City of Albuquerque

RE: DRAINAGE PLAN FOR OAKCREST ESTATES (L-22/D44) RECEIVED
DECEMBER 3, 1986

RE: REVISED DRAINAGE PLAN FOR OAKCREST ESTATES
(L-22/D44) RECEIVED OCTOBER 8, 1986

GRADING & DRAINAGE PLAN OAKCREST ESTATES

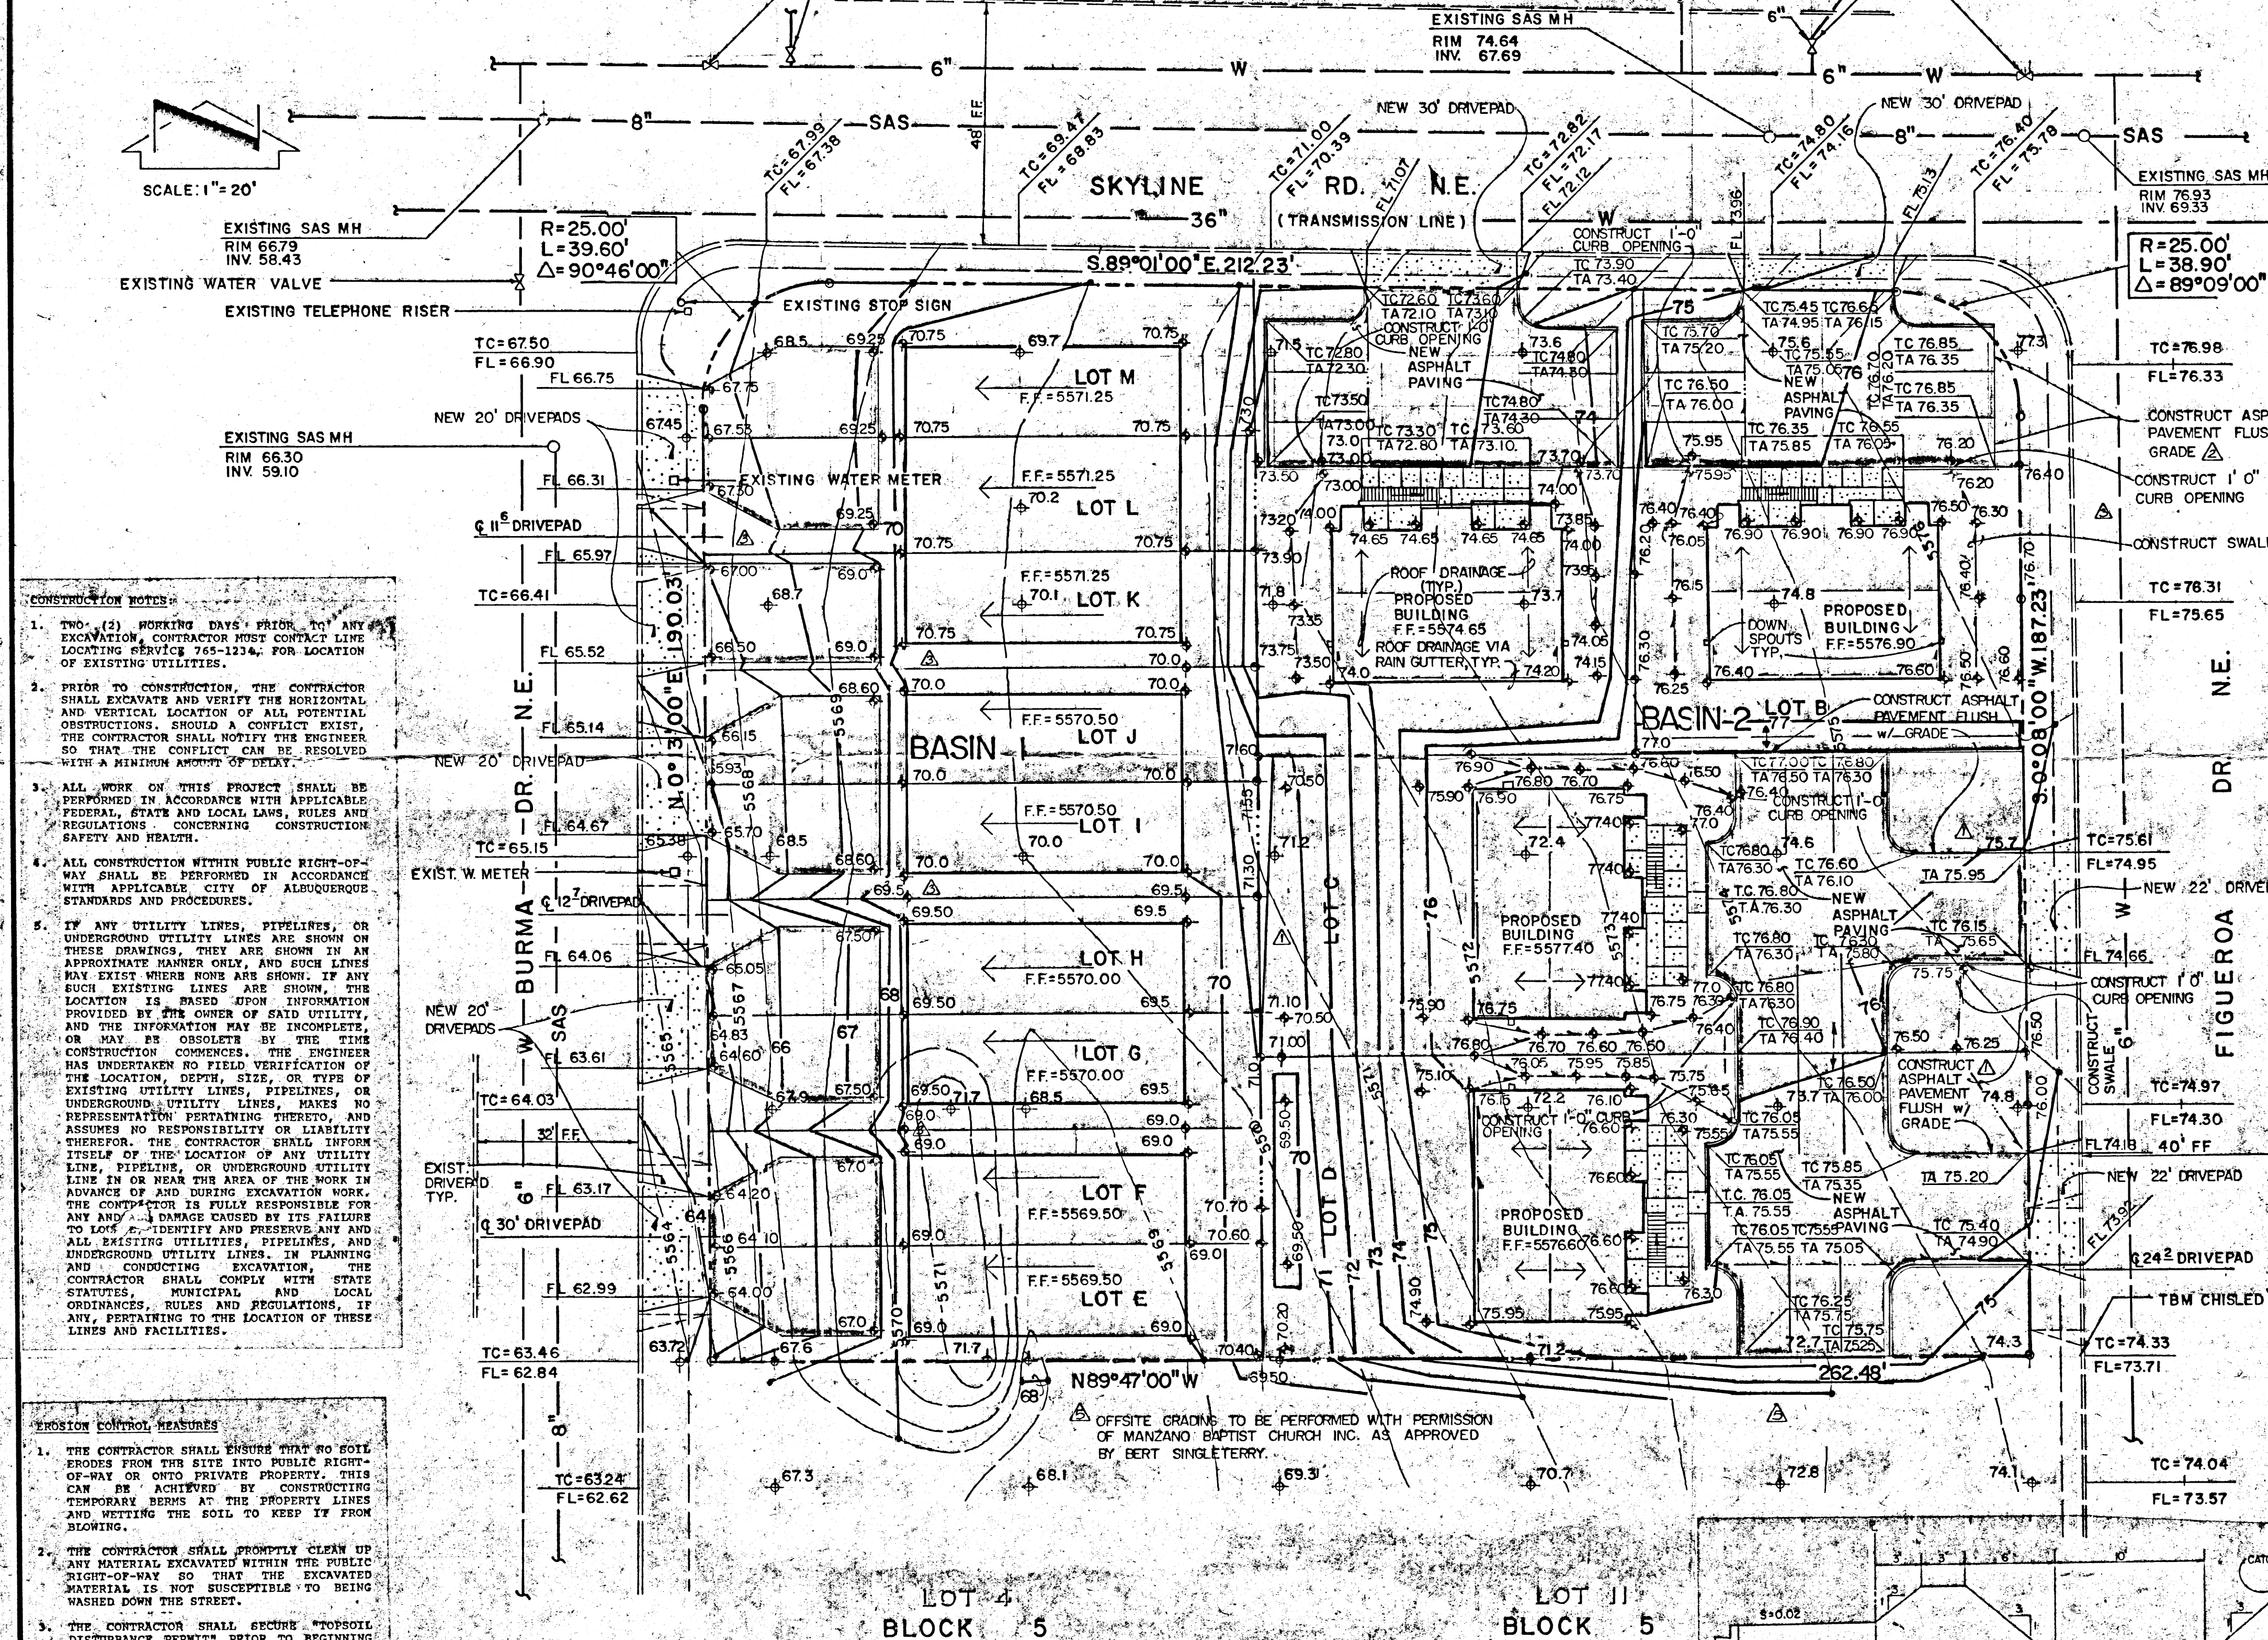
The above referenced plan, dated December 3, 1986, is approved. Please be advised that retaining walls need to be in the infrastructure list.

1. The intent of this submittal is unknown other than to provide an update. The revision identifies the deletion of a portion of curb. The previous submittal did not show any curb in these areas at all to start with.

2. The previous comments do not appear to have been addressed. Therefore, I will have to reiterate that in order to receive approval, the adjacent property owner will be required to provide this office with written approval for the off-site grading as shown on this plan. The other option would be for the owner to sign this plan to indicate that he has seen the proposed grading and is in agreement with it. It also appears that the other comments from Mr. Montoya's letter, dated October 7, 1986, have not been addressed. Once these comments have been satisfactorily addressed and approved, then this office may issue an approval letter allowing you to proceed with the request for a building permit.

- A. Written permission to grade on adjoining property.
- B. Drainage Covenants or Easements from downstream property owners to discharge across their property.
- C. Please indicate where the flows will be conveyed through downstream of Lots C and D.

I cannot address all the
specific items that I am finding
on this plan. However, a couple
of specifics are as follows; 1) Some
of the areas between the proposed
structures show some spot elevation
that are adverse to the flow arrows
as indicating the drainage intent;
2) There are obviously 3 separate
drainage areas involved in
this development yet, it has all

been lumped together into one ~~a~~
for the purpose of calculations.

Also, the developed area is identified as approximately 11 acres. The site presented on the plan only encompasses about 1.3 acres.

1. The developer has decided to construct a retaining wall along the south property lines of Lots D and E which will eliminate offsite grading.
2. Runoff generated onsite will be confined within the specified lots.
3. Flows generated onsite will no longer discharge onto Lots C and D due to the construction of the retaining wall.
